16. APPENDIX J - SCHEDULE OF DRAINAGE PLAN REVISIONS

SCHEDULE OF MINOR CHANGES TO APPROVED SURFACE WATER DRAINAGE DRAWINGS

CLIENT		
LANDLINK ESTATES		
PROJECT		
SALTBOX BOGNOR REGIS		
TITLE		
HEADWALL DETAILS		
HYDROCK PROJECT NO. C-13319-C		SCALE @ A1 1:25
STATUS DESCRIPTION AS BUILT ISSUE		STATUS A
DRAWING NO. (PROJECT CODE-ORIGINATOR-ZONE-LEVEL-TYPE-ROLE-NUMBER) SAL-HYD-00-ZZ-DR-C-7110		REVISION C04

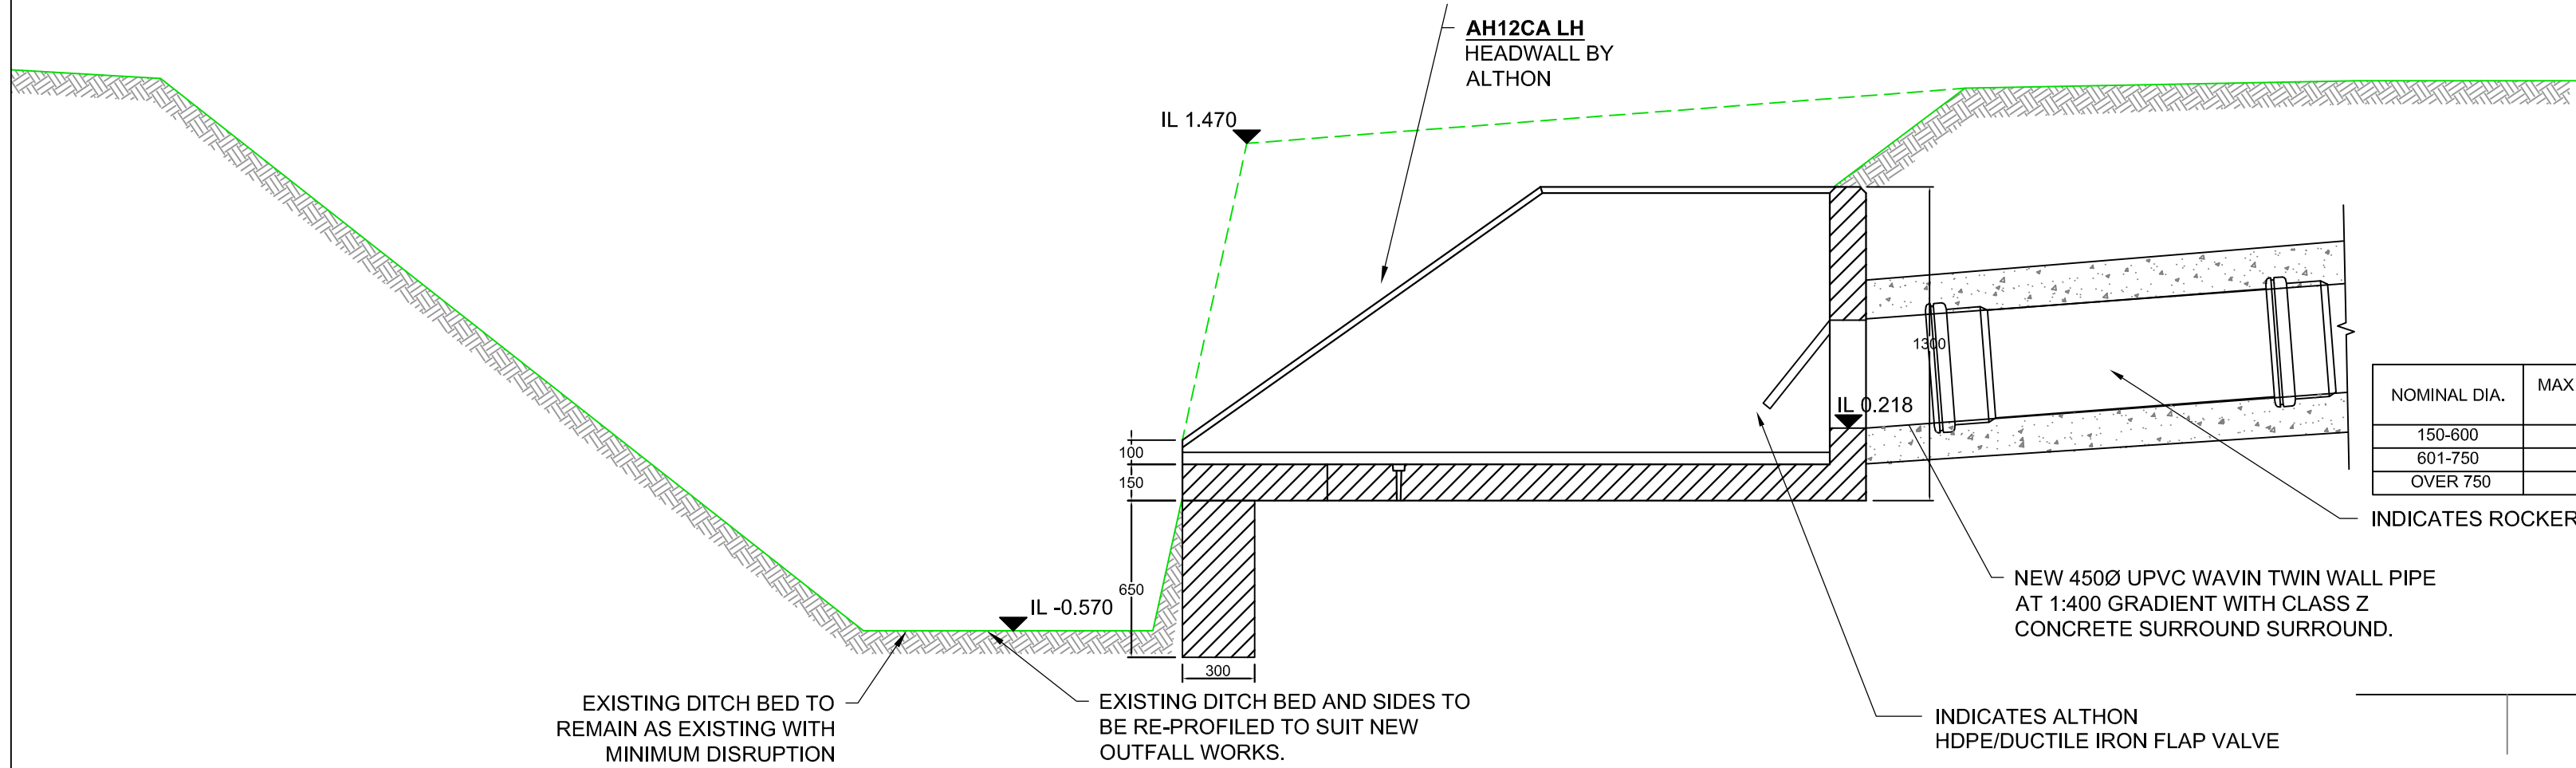
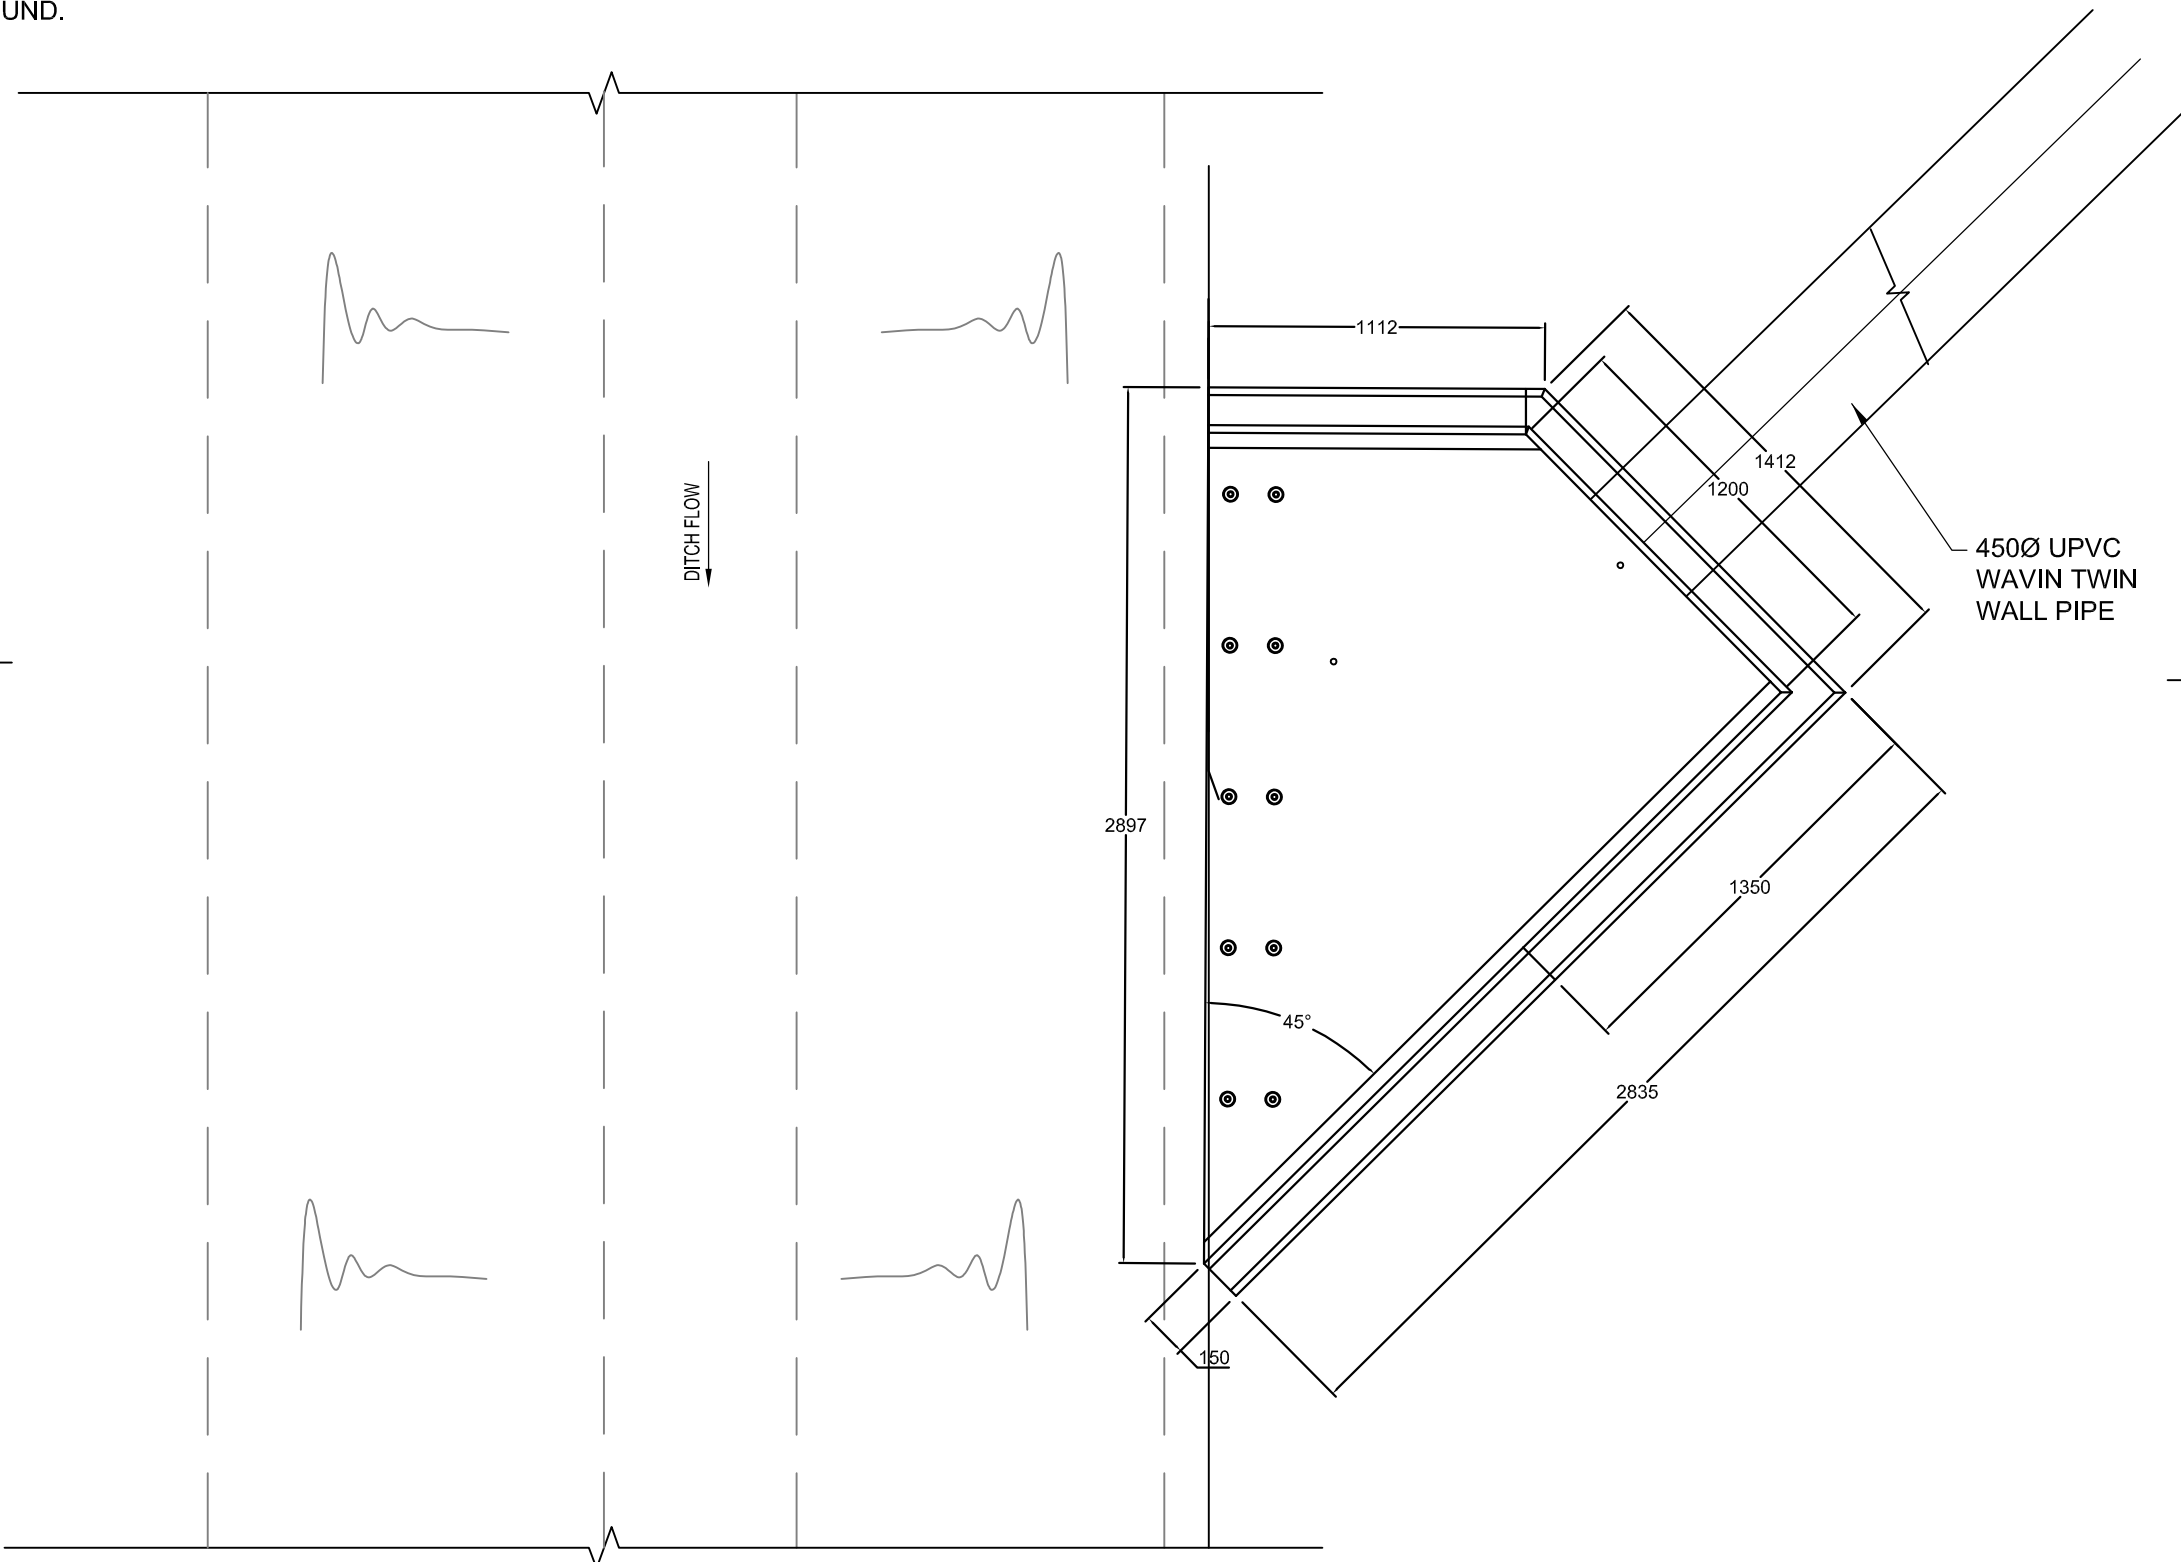
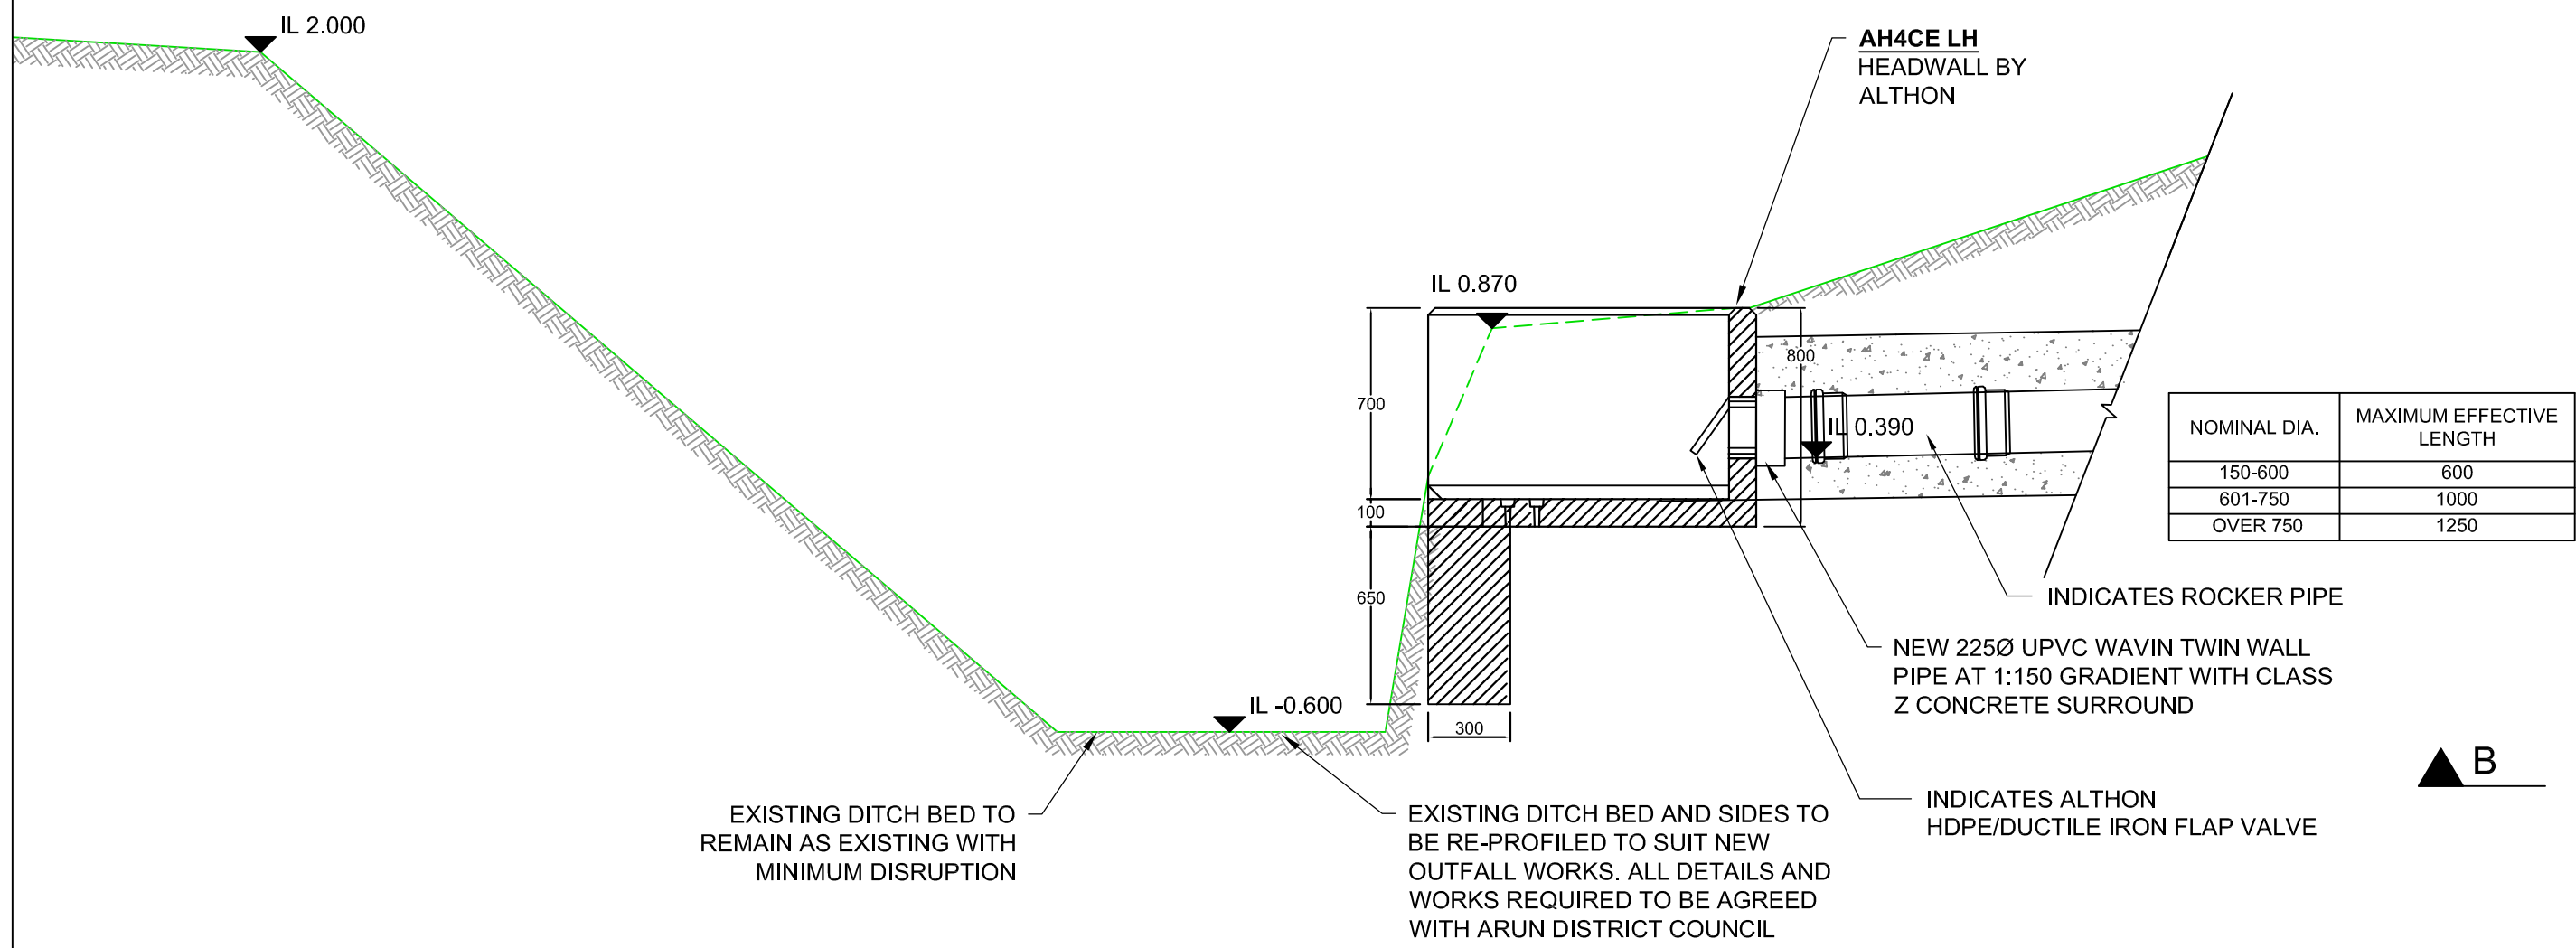
SAL-HYD-PH1-ZZ-DR-C-7110			
Rev P04	ARUN Approved Issue.		
Rev C01	Construction Issue *no changes*		
Rev C02	Headwalls updated.	Headwall changed to be more angular. At the request of ARUN	Detail angled to discharge with the flow direction.
Rev C03	H&S Issue - title block changed	title block changed	Error corrected
Rev C04	As built Issue - title block changed	title block changed	Changed back to As-built
SAL-HYD-00-ZZ-DR-C-7721			
Rev P01	ARUN Approved Issue. Approved under BE21/20/DOC on 11/6/20		
Rev P02	Updated to remove Unit 3 from site plan	Plan base changed to reflect removal of Unit 3 (outline) footprint from base plan	NMA approved to change bell mouth into Unit 3 and removal of detail from that outline site. All other plans revised to reflect this change at planning officer request.
SAL-HYD-PH1-ZZ-RP-C-0010			
Rev 06	ARUN Approved Issue.		
Rev 07	Information updated to remove unit 3 from plans	Plan base changed to reflect removal of Unit 3 (outline) footprint from base plan	NMA approved to change bell mouth into Unit 3 and removal of detail from that outline site. All other plans revised to reflect this change at planning officer request.
